CPP Project 6011

Subject: Wind Engineering – Frasers Broadway Block 2, Section 75W

Ref: (1) CPP Environmental Winds Report 4946 dated July 2009

PODIUM AWNING DETAILS SHEET

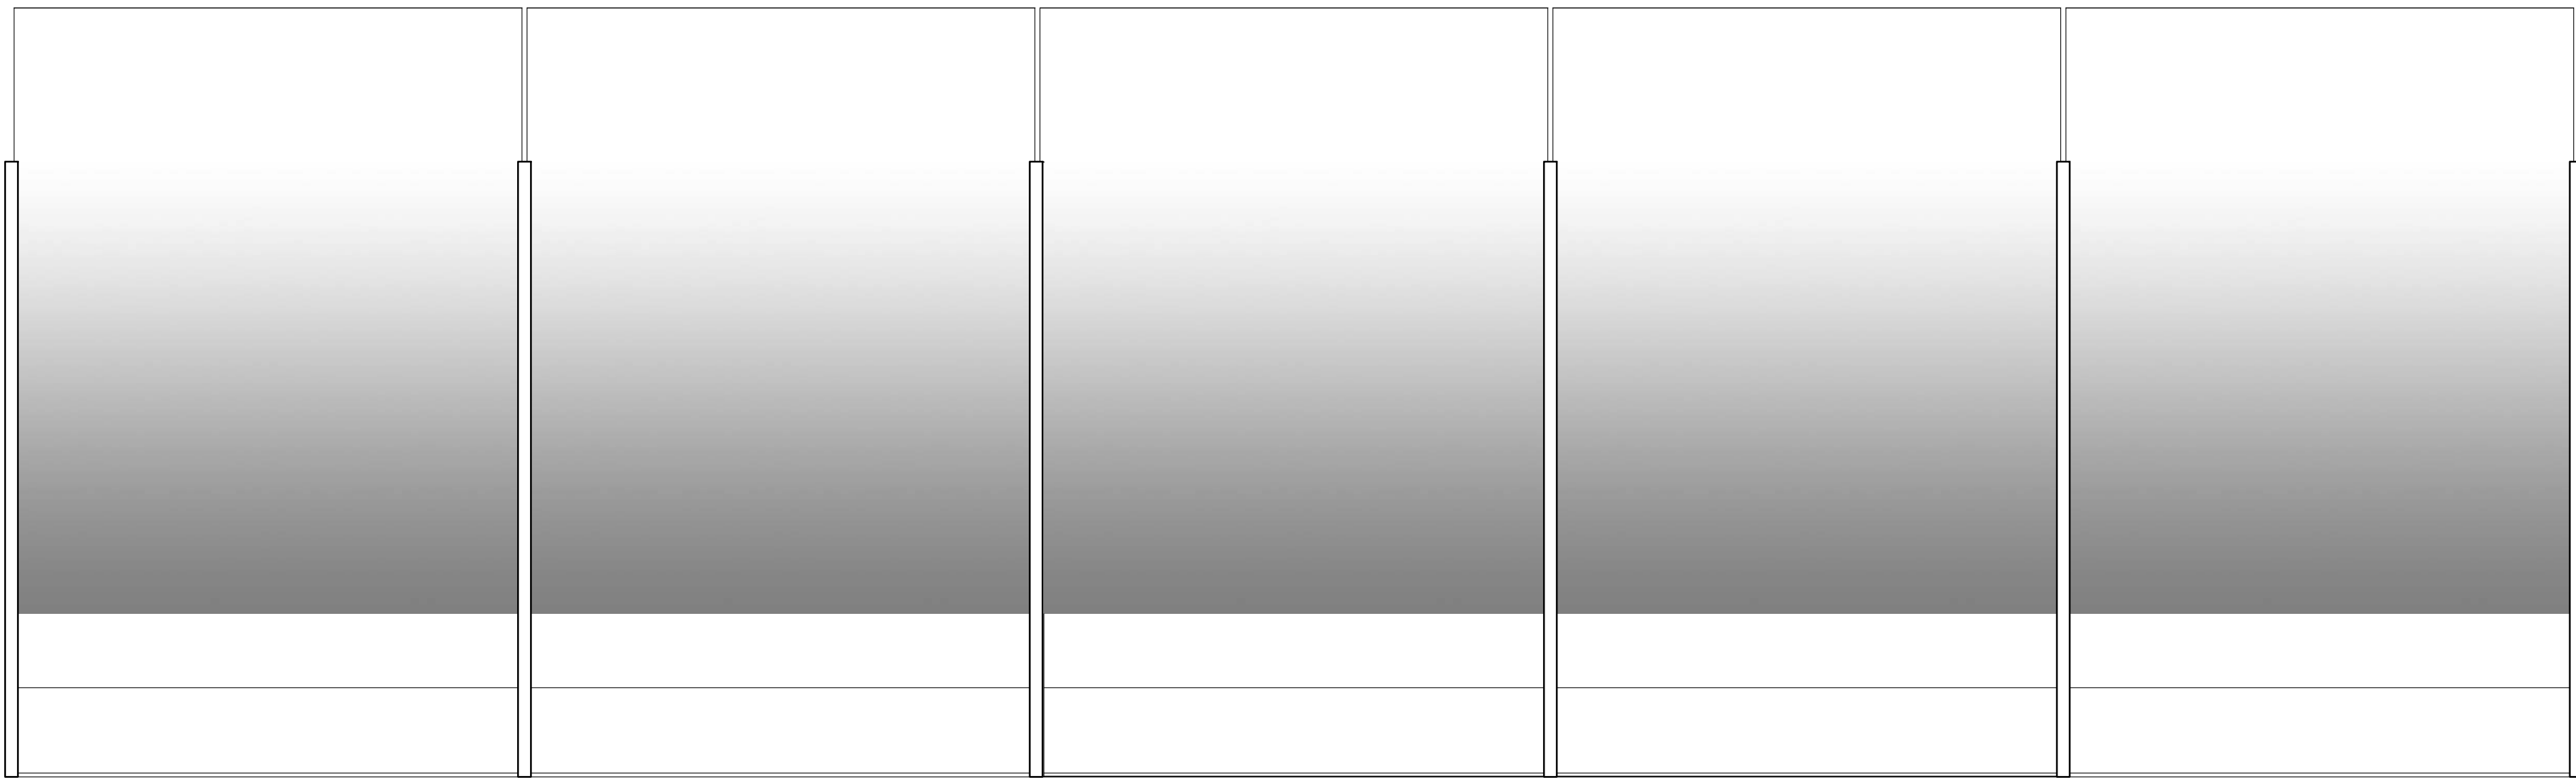
The change to the building geometry from a wind perspective is the lifting of the 3 m wide Broadway awning to Level 2 and wrapping it around the north-east corner of the building to beyond the Entrance Gate. The awning along the eastern façade is 3 m wide located above the colonnade roof at Level 2.

The current change in geometry complies with the recommendations provided in the wind tunnel test report of July 2009. With the current change in awning configuration the wind conditions around the north-east corner will improve and are expected to be similar to the wind tunnel test results indicating windy, but acceptable conditions. The wind conditions along the remainder of Broadway with the increase in awning height from Level 1 to Level 2 are expected to remain classified as acceptable for pedestrian standing activities.
